From: Joyce Christie
Sent: 06 May 2025 16:34
To: Shona King
Cc: DC Support; Nathanael Stock
Subject: RE: 25/00527/DISC North Arms

Discharge of Condition 9 (details of structural opening) of 24/01880/LB

SCALE	DATE	DESIGN/DRAWN	CHECKED	APPROVED	SHT
1:100	APR. 2023				
22070					
22070/P11					REL. D

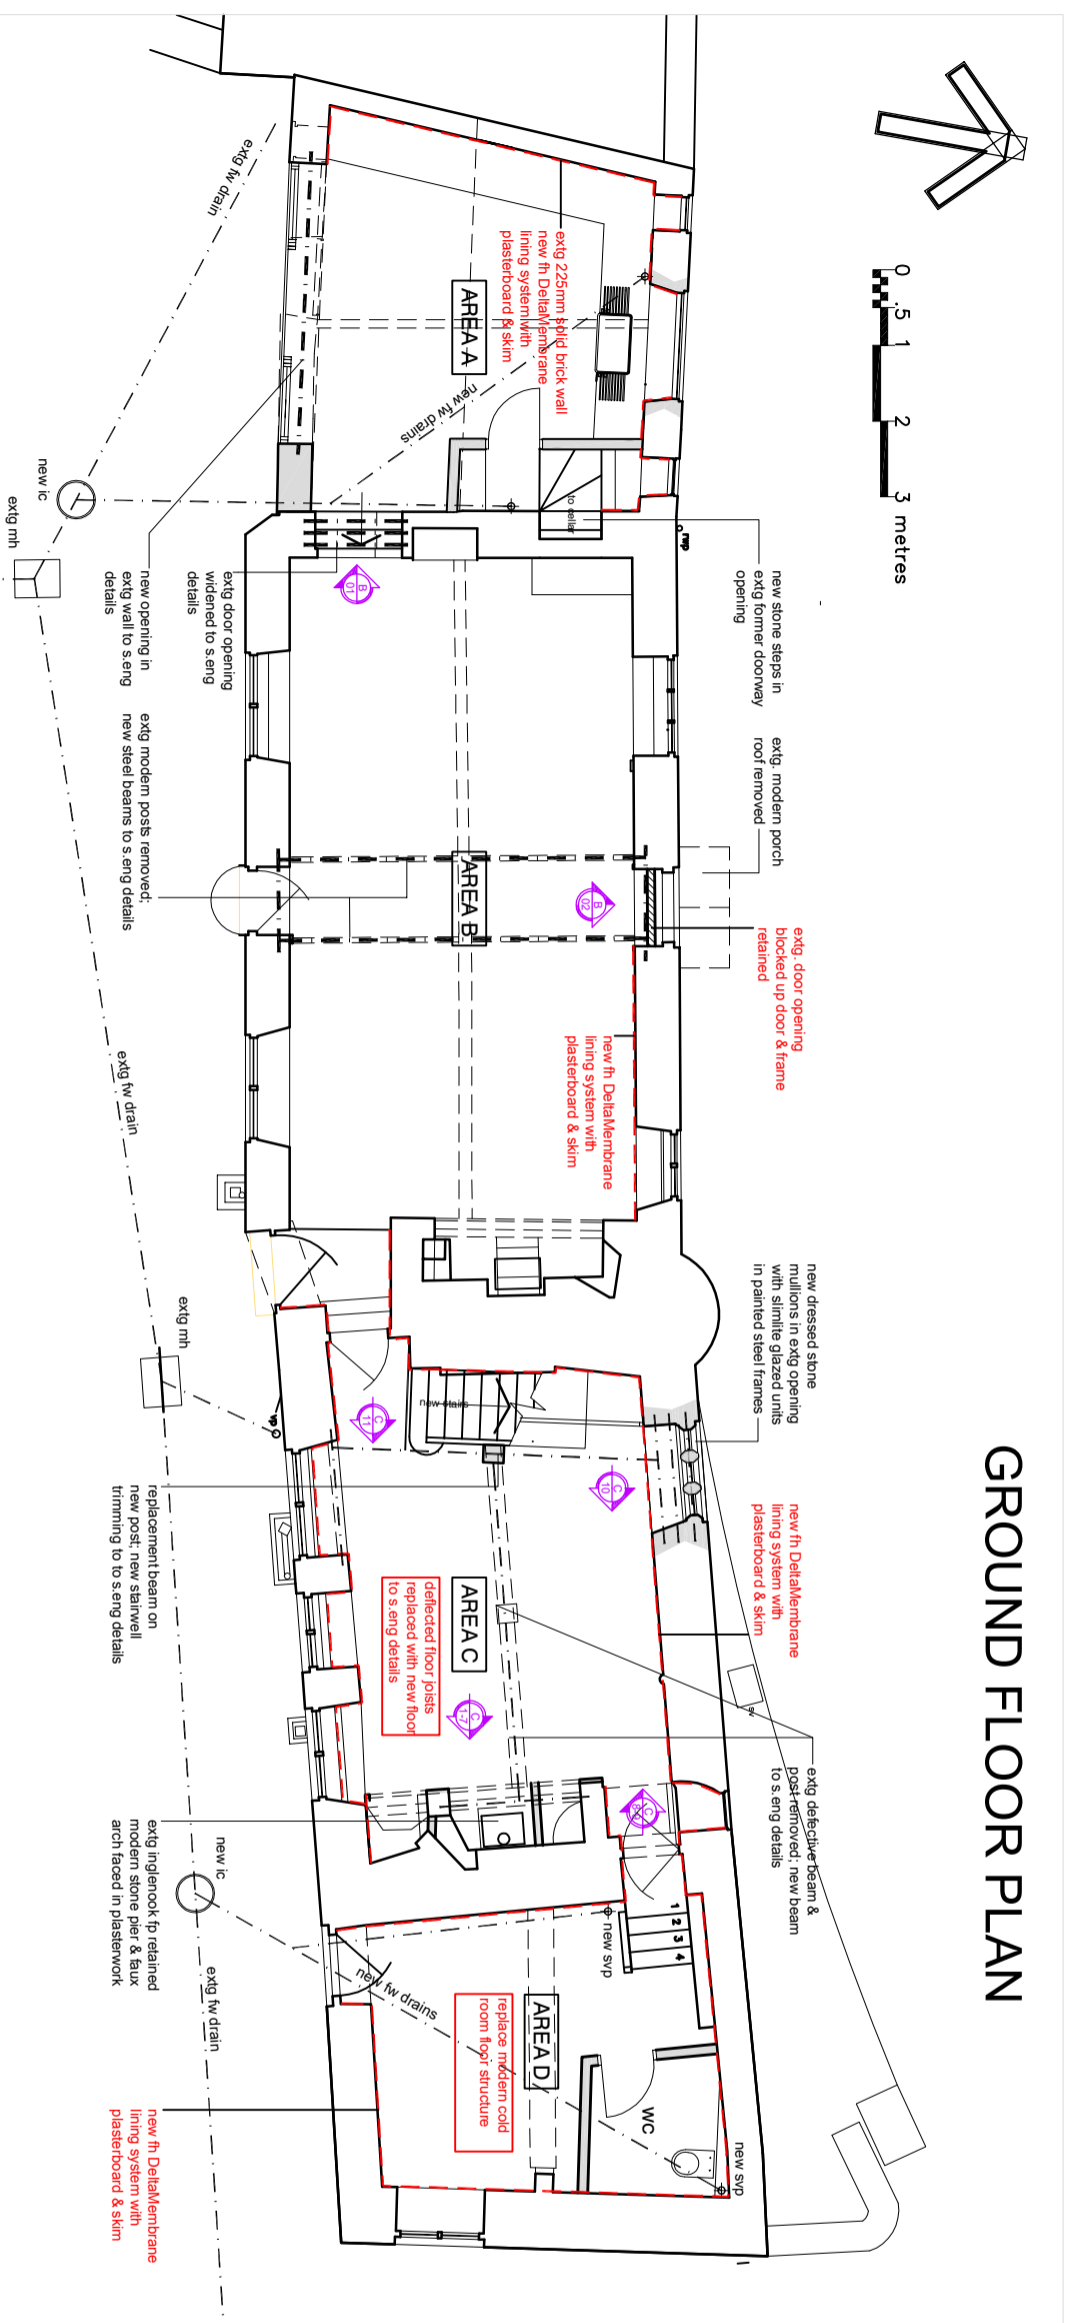
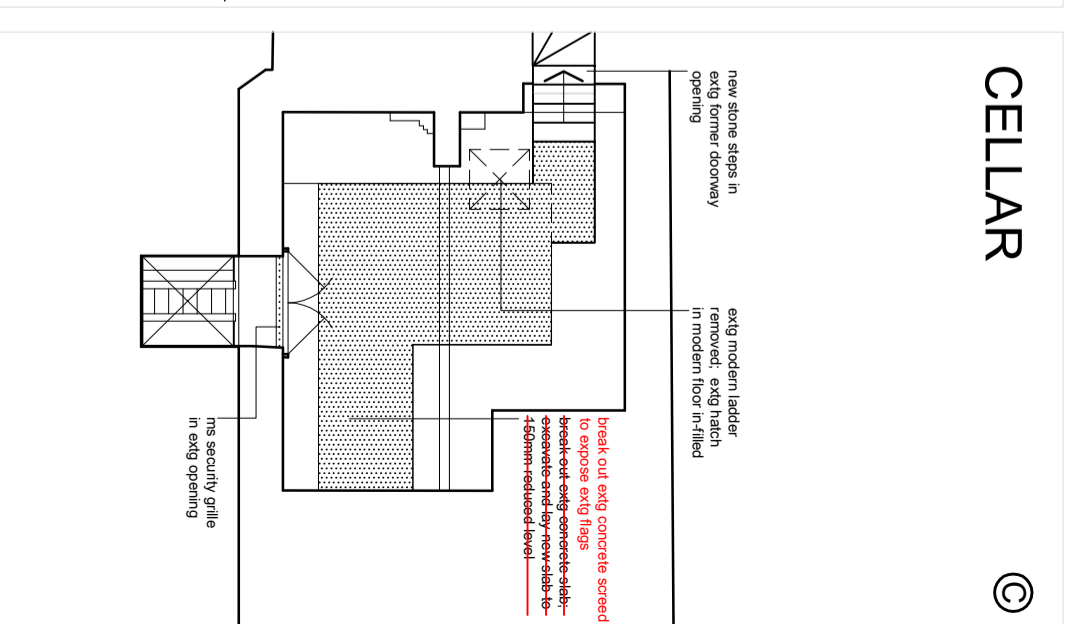
P11D shows the whole floor plan. Drawings 12C and 13B were also submitted but these are not relevant to Condition 9 of 24/01880/LB.

Please ask for a bit more information on Drg P27 to show the existing floor slab junction with the new floor slab and how the ceiling finishes between the existing and proposed relate to one another. Please also confirm how the new steel that is to be inserted to support the ridge of the new roof will be embedded in the masonry. Can they supply further detail on the junction between the extension roof and the stone pier between the large opening and the door. Please note Drg P11D and P27 are different as P11 doesn't show a door and appears to show a wider opening?

The existing modern floor slab of concrete on brick hardcore was impacted by the former brick partitions of the pub wc provision and also the introduction of the cellar steps. A new wide boarded oak floor is proposed to be laid over throughout the existing and extension area.

The purlin steels will be inserted in the masonry (brick and stone) on padstones to the structural engineers' details. The junction of the extension roof and existing pier will comprise timber valley rafters resting on the new steel purlins.

Drawing P11D continues to relate to the original approval ref.: **22/03307/F & 22/03308/LB** in order to highlight the variations, as now requested. Drawing P27 relates to the subsequently Consented kitchen extension ref.: **24/01879/F & 24/01880/LB**

Floor – agreed.

Purlin steels – agreed.

P11D and P27 – noted.
